339-D-009001

Barclay Avenue Lot Division  
Project Name/Description

Memorandum  
Department of Planning and Development  
Planning Division

Re: Barclay Avenue Three Lot Subdivision, vicinity 35 Barclay Avenue  
APPENDUM #1

Drawing Name: **Lot 3 Grading & Drainage Plan**  
Project: **BARCLAY AVENUE, PORTLAND**

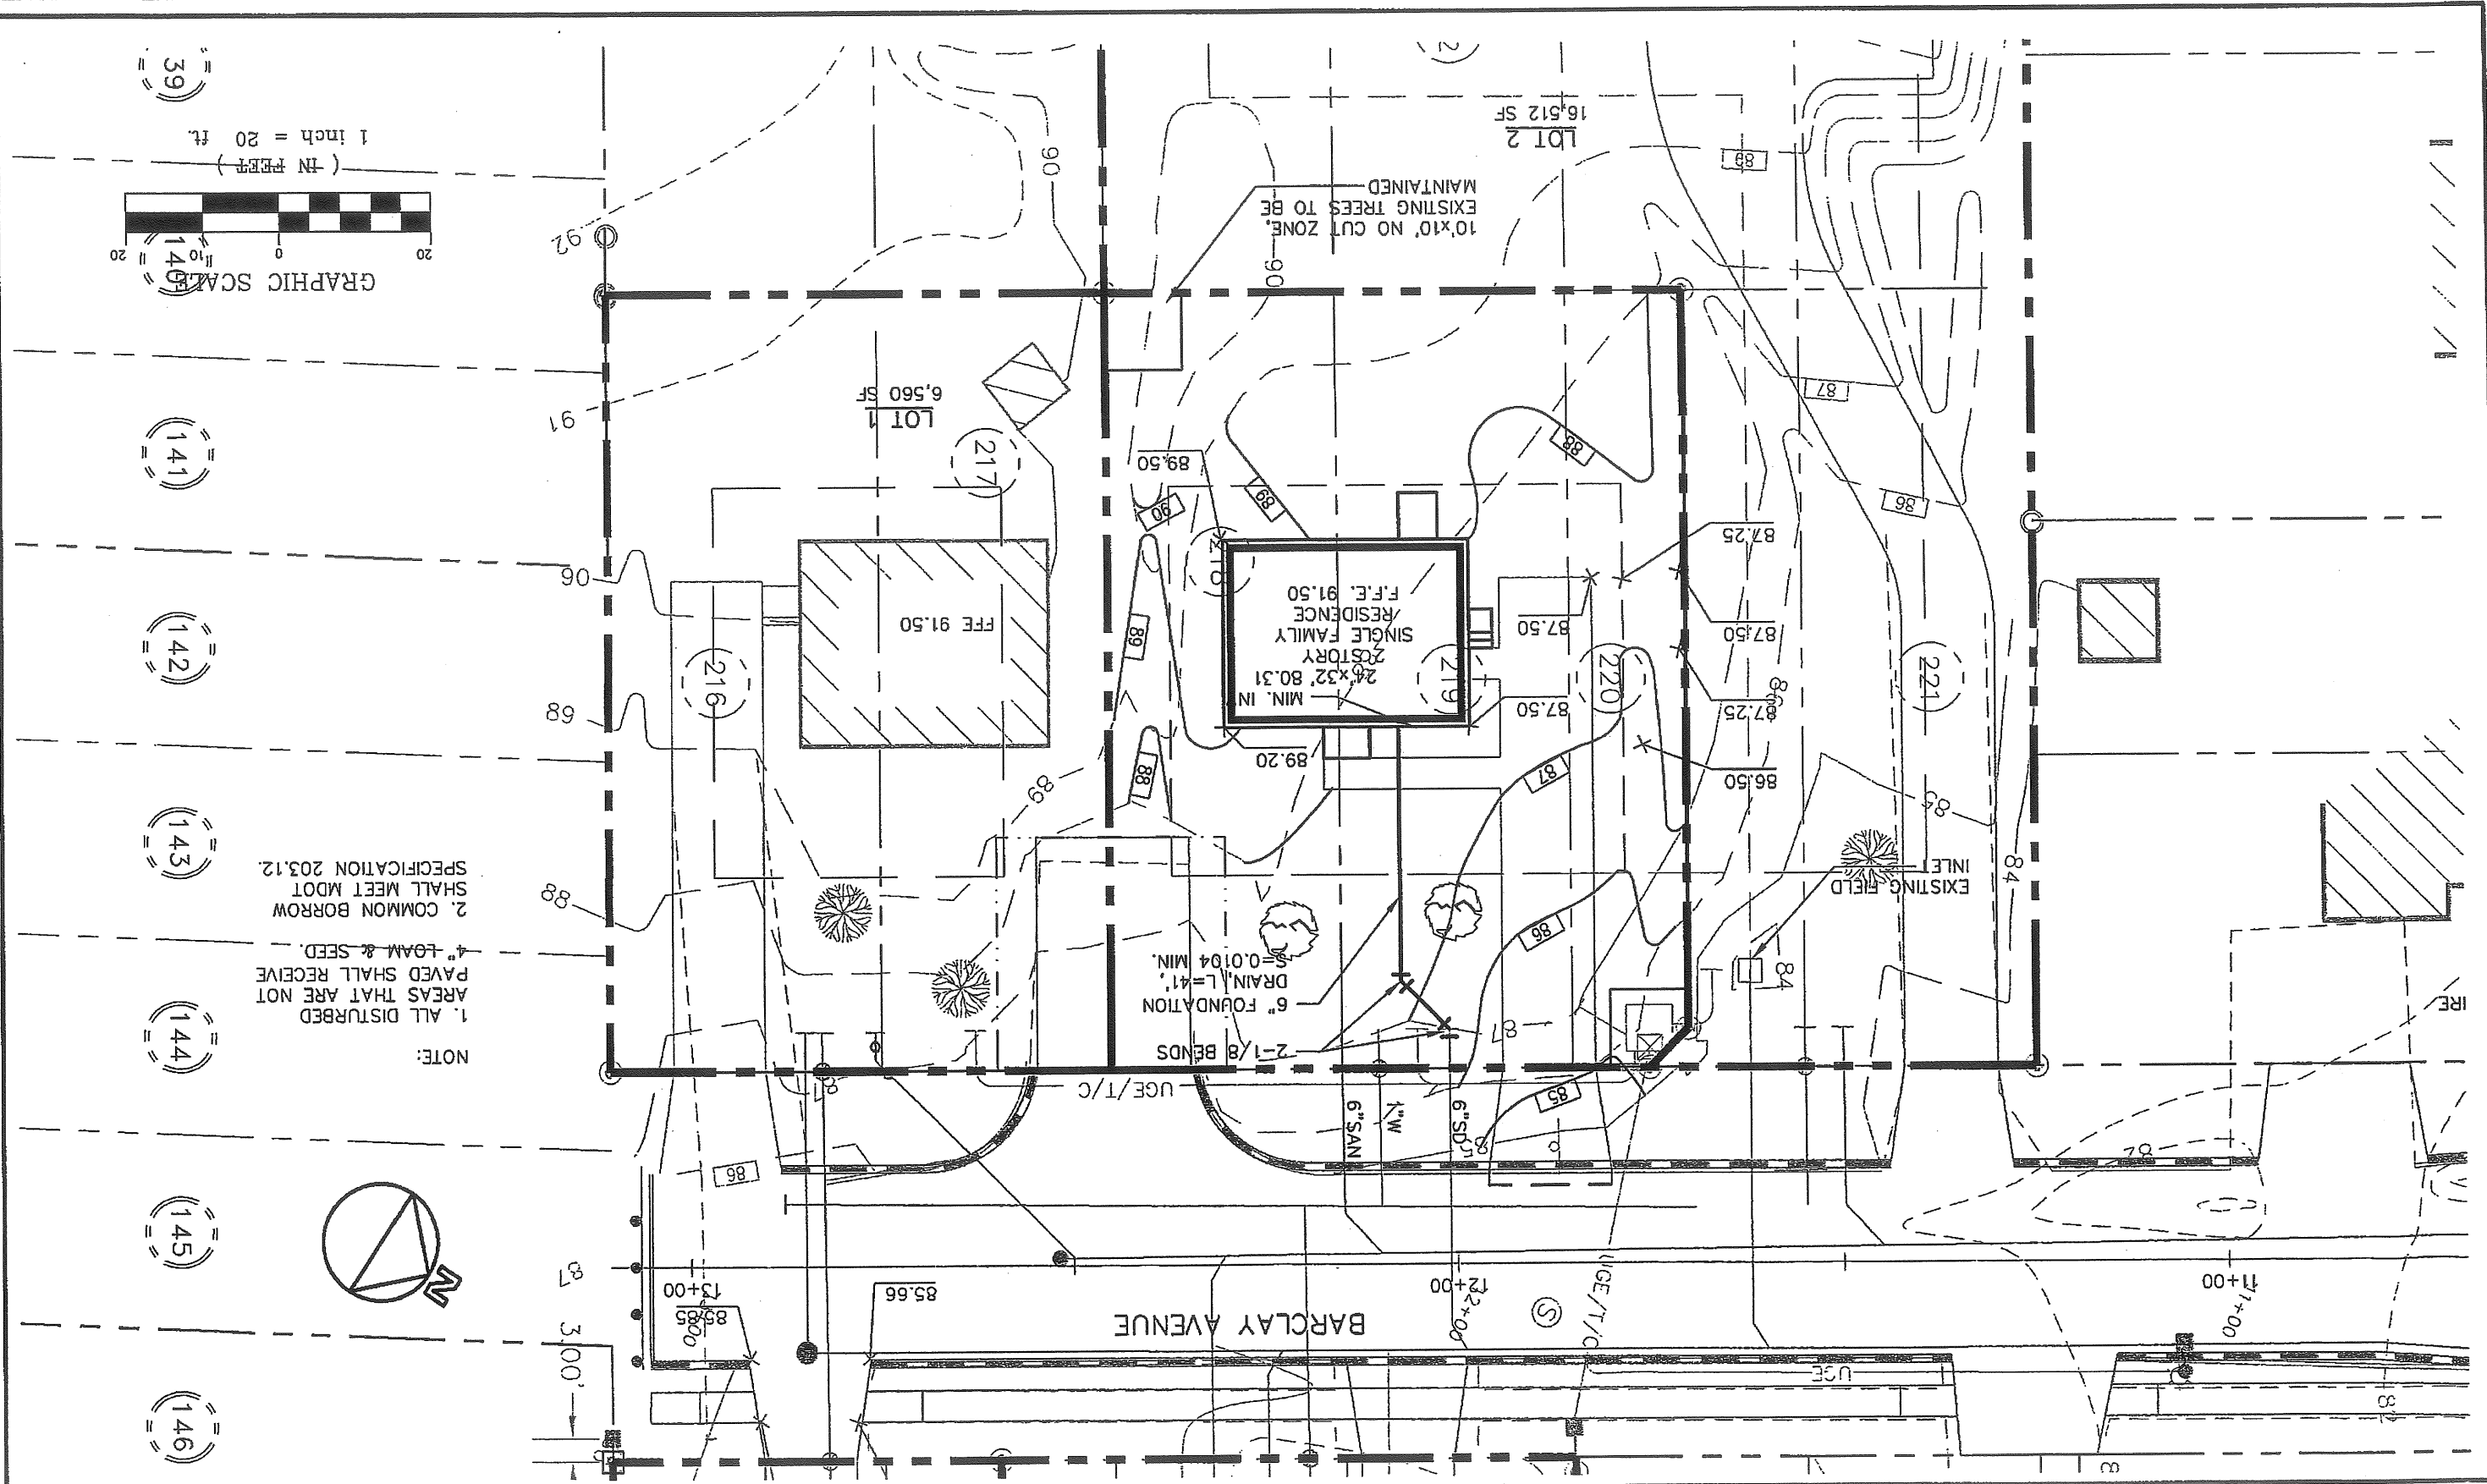
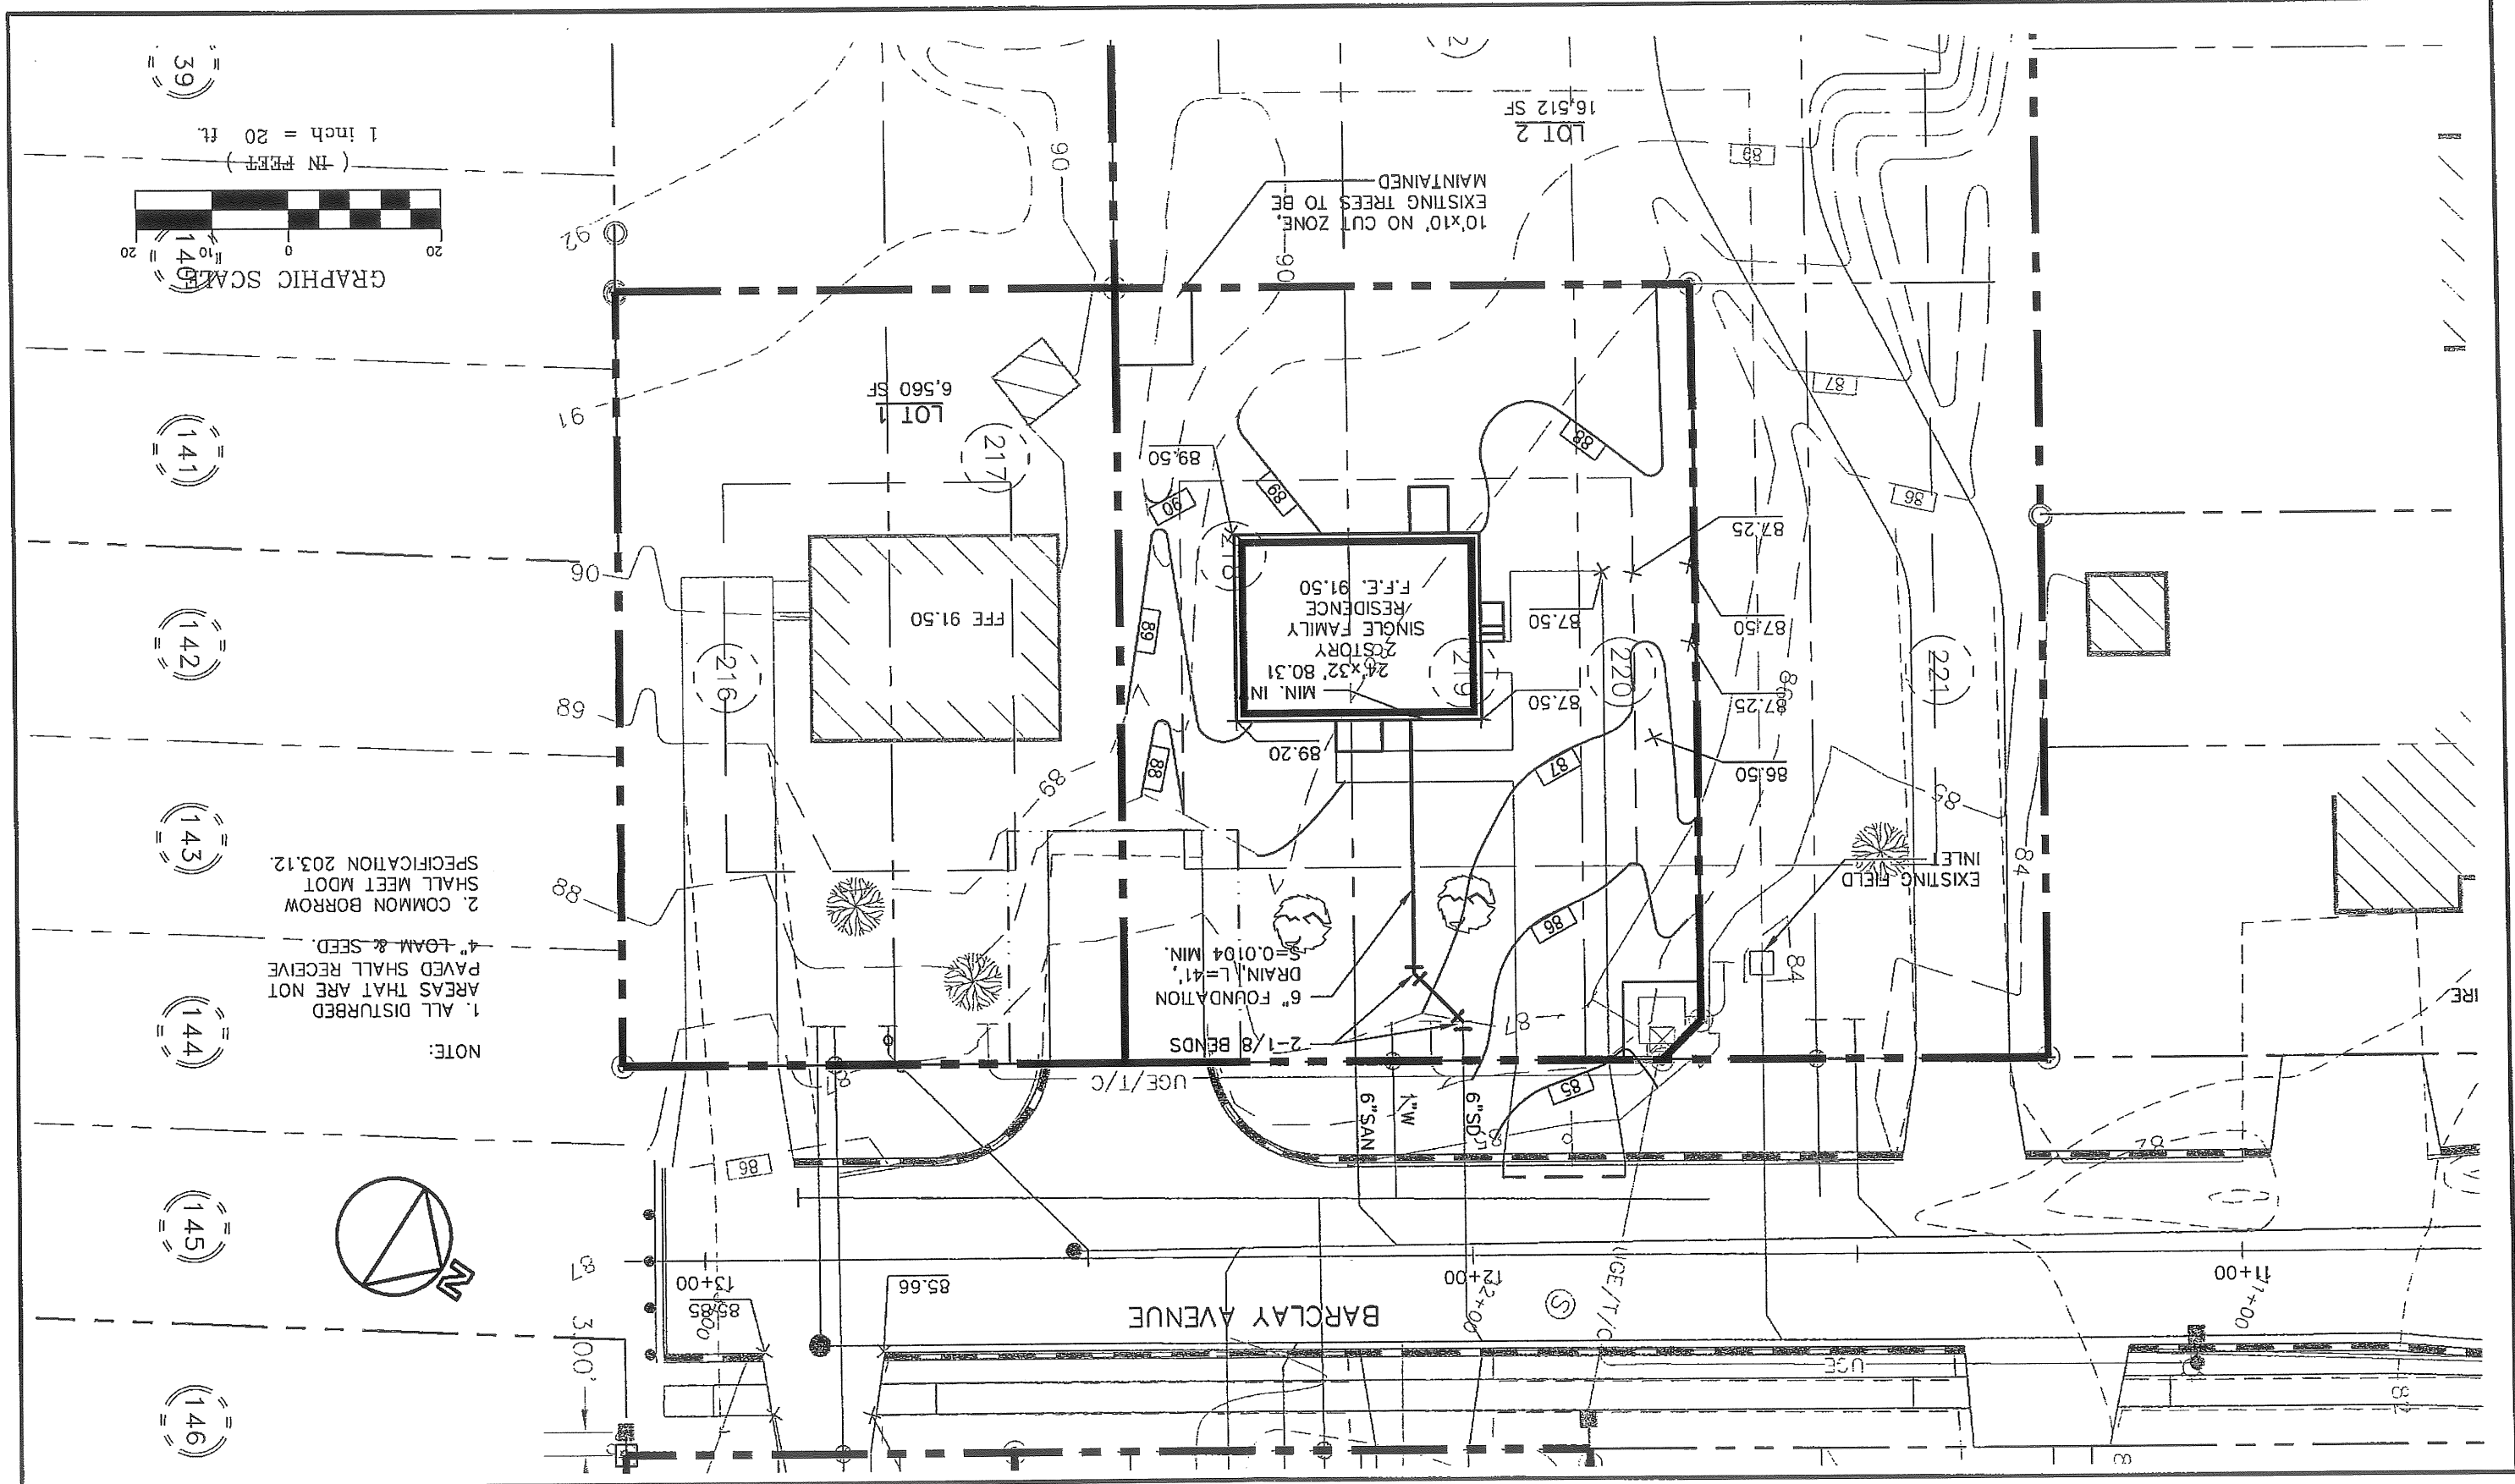
- ii. The applicant shall present evidence of a satisfactory drainage easement in respect of Lot 2 (field inlet) for final review and approval by Corporation Counsel, and provide additional easement(s) for review and approval if determined appropriate; and

- iii. The applicant shall secure, submit for review and approval by Corporation Counsel, and show on the Subdivision Plat, an executed construction easement for the ditch area between Lots 1 and 3; and

- iv. In the event one or both of the easements referenced in conditions ii and iii are not secured, the applicant shall submit, for review and approval prior to the registration of the Subdivision Plat, revised grading plans that ensure all storm water remains on Lot 3; and

1. I have had recent discussions (on 6/8/2007) with Jim Wolf and his Engineer, Doug Reynolds, regarding the grading and drainage issues and the swale/ditch line that already exists on my property at 39 Barclay Avenue. As you are likely aware, there has been a significant amount of back and forth on these issues. The City Engineer, Dan Goyette, has commented that there is a high spot on my lot that "prohibits runoff from the rear of Lot 1 and potentially Lot 3 from enter the ditch line and flowing out to the street" (5/29/2007 memo).

Based on this recommendation, I do still have some concerns about possible drainage issues and wet areas that I may experience as a direct result of the new structure to be built at 35 Barclay Avenue. I would like to note that since I moved into the house at 39 Barclay in 2003, I have had water issues on that side of my lot on a regular basis. For example, after heavy rains, it takes a considerable amount of time for the water to flow out to the street. In addition, after a recent spring storm, I noticed that – due to the extra moisture in the earth – the concrete blocks on one side of my shed have sunk into the ground. For these reasons, I can only surmise that the situation will not be improved by the addition of another house next door.

1) A condition that requires the developer to remedy any possible future drainage/water issues on the right-hand side of my lot abutting the site to be developed. In addition, I would also like to make certain that the builder/developer is required to correspond with me regarding any changes he/she plans to make to the existing ditch line.
